**Essex County Council (ECC) - Written summaries of
Oral submissions made at Issue Specific Hearing (ISH) 1 and 2 (2 April to 8 April 2025)**

ISH 1 (2 April 2025 to 4 April 2025)

<b>Project</b>	North Falls Offshore Wind Farm
<b>Document Title</b>	Onshore Substation Zone of Theoretical Visibility and Viewpoint Locations with Dedham Vale National Landscape
<b>Document Reference</b>	9.62
<b>Supplier</b>	LUC
<b>Supplier Document ID</b>	PB9244-LUC-ZZ-ON-DR-GS-0041

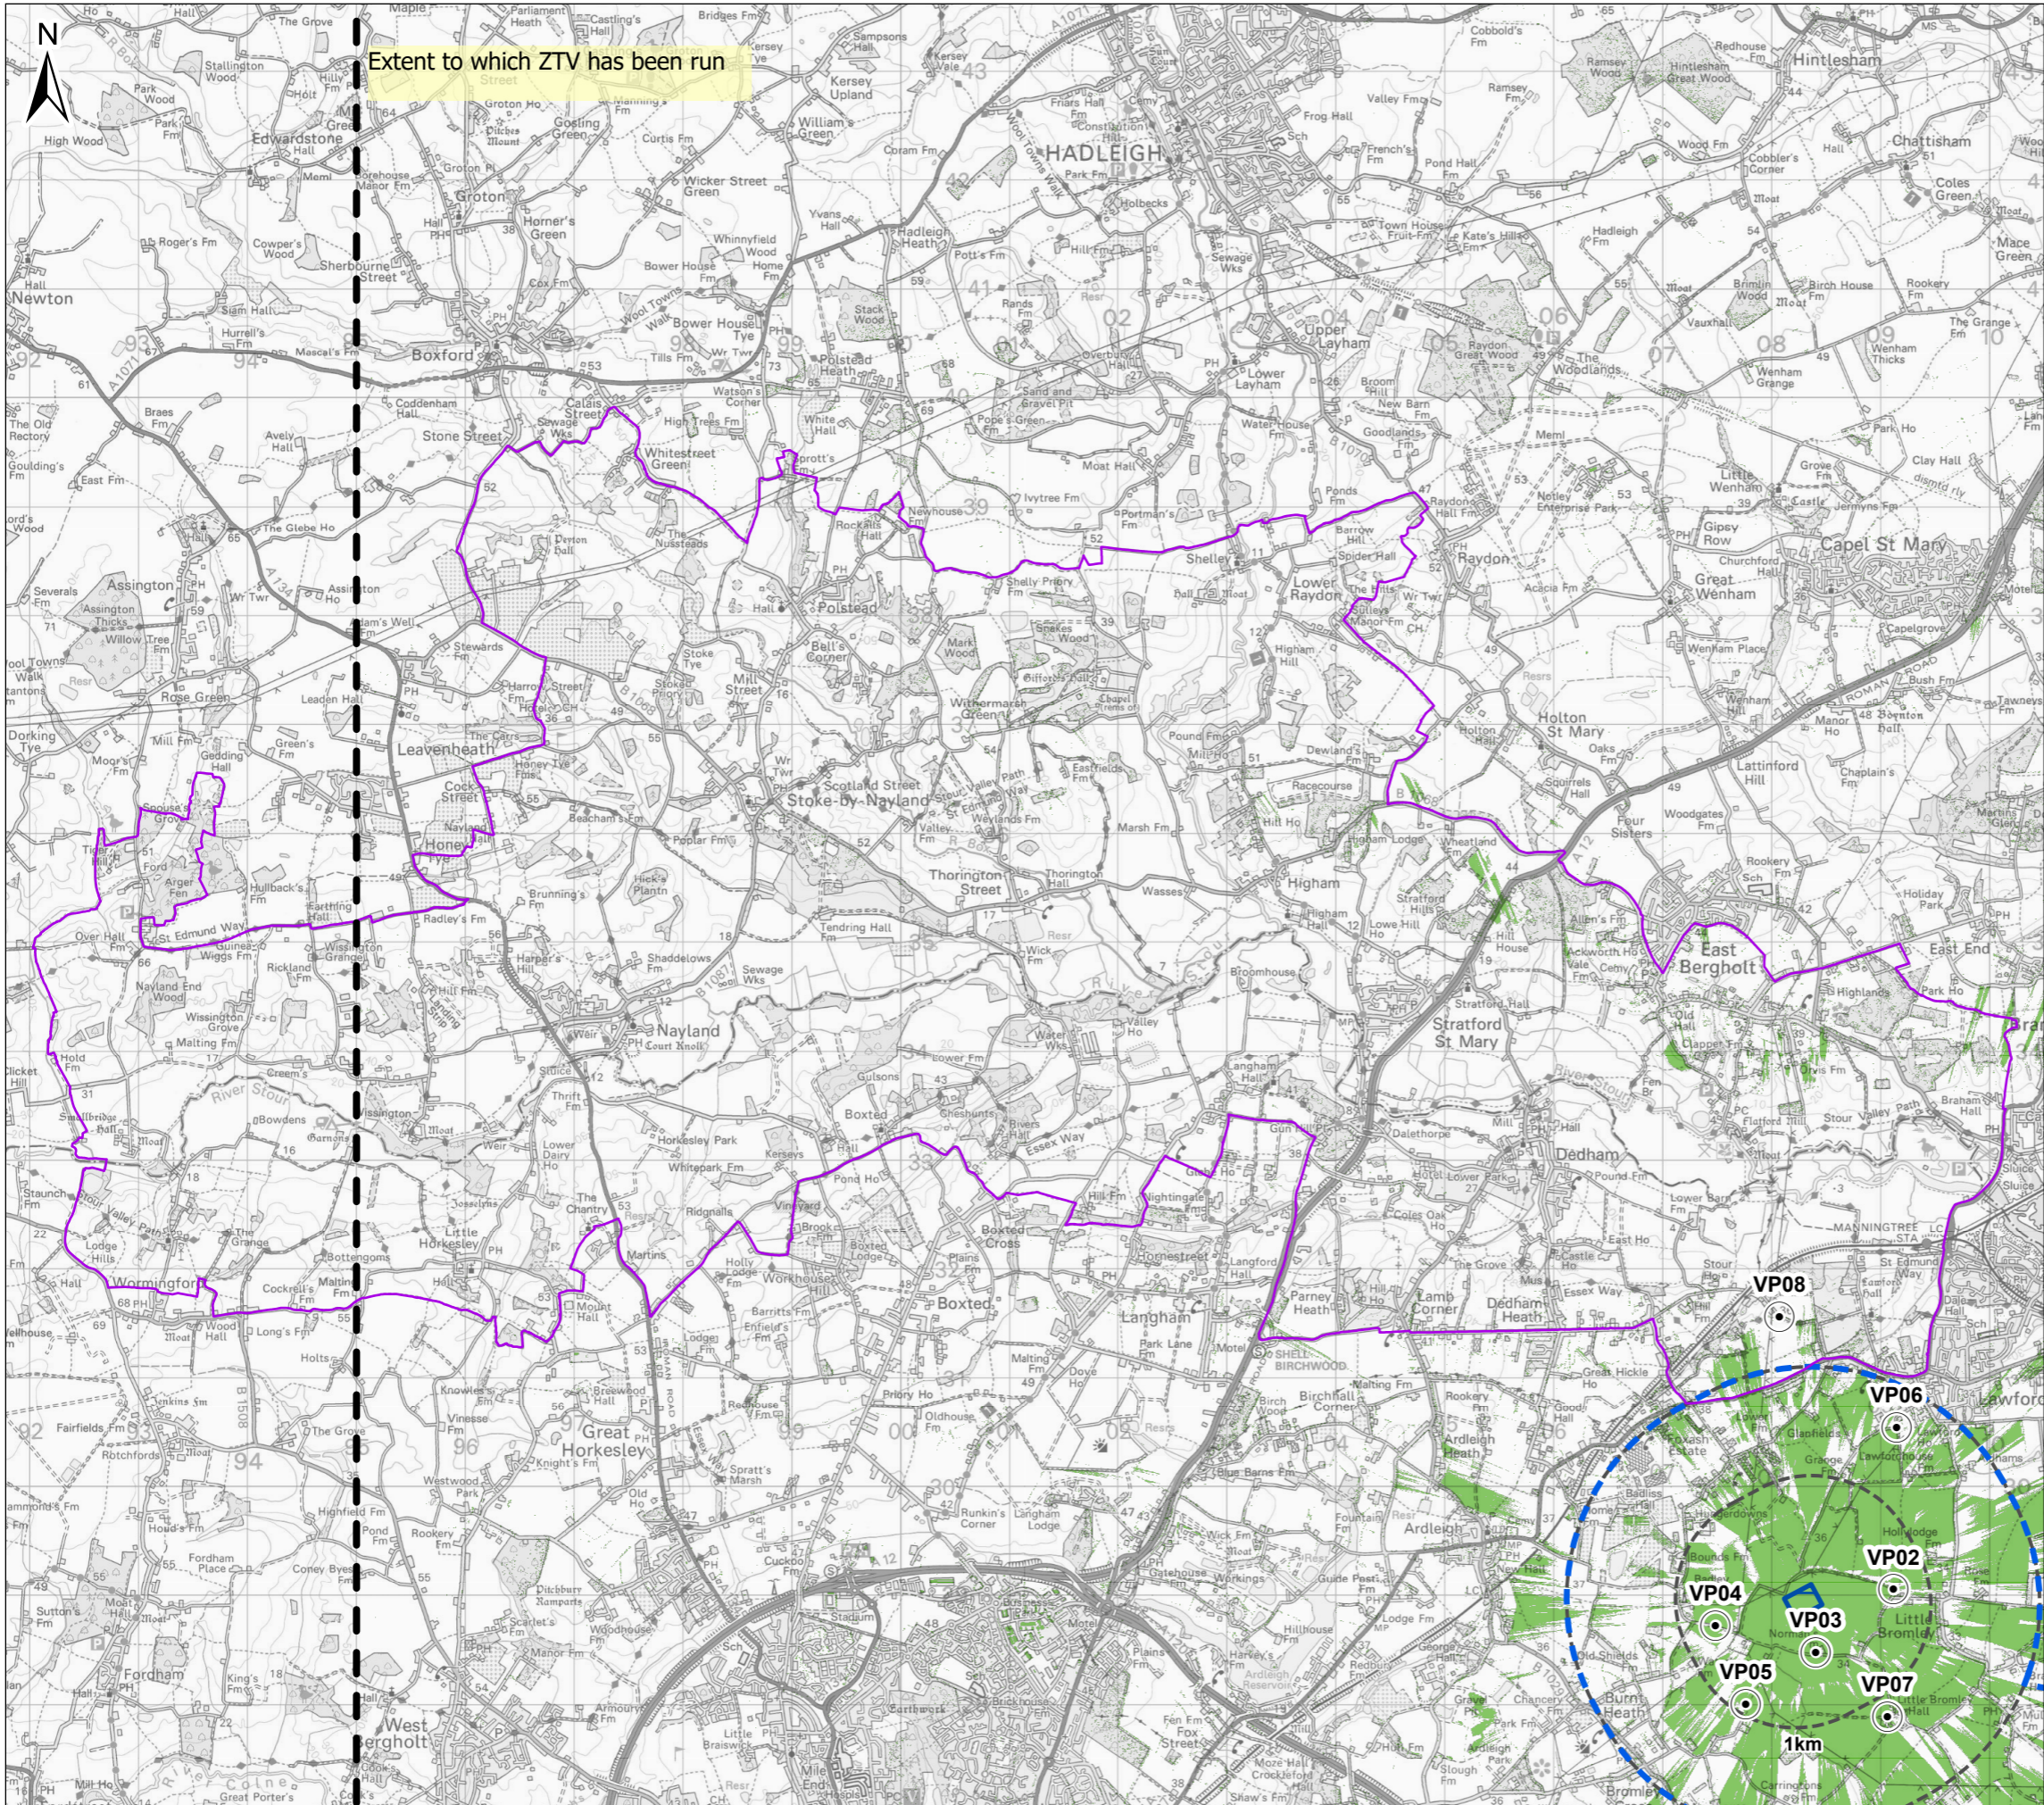
We remain concerned about the number of viewpoints from Dedham Vale National Landscape. We raised about this during the Five Estuaries (VE) Examination and VE did 2 additional viewpoints for us in the Dedham Vale, showing what the impacts would be cumulatively as well as with other proposals in this area, including the East Anglian Connection Node (EACN) and the overhead lines. The overhead lines are of particular concerns for all the councils involved here. During the NFOW hearing, ECC requested that the Applicant provide a plan showing the boundary of the Dedham Vale National Landscape in relation to the location of the proposed substation – this was not included in the Environmental Statement.
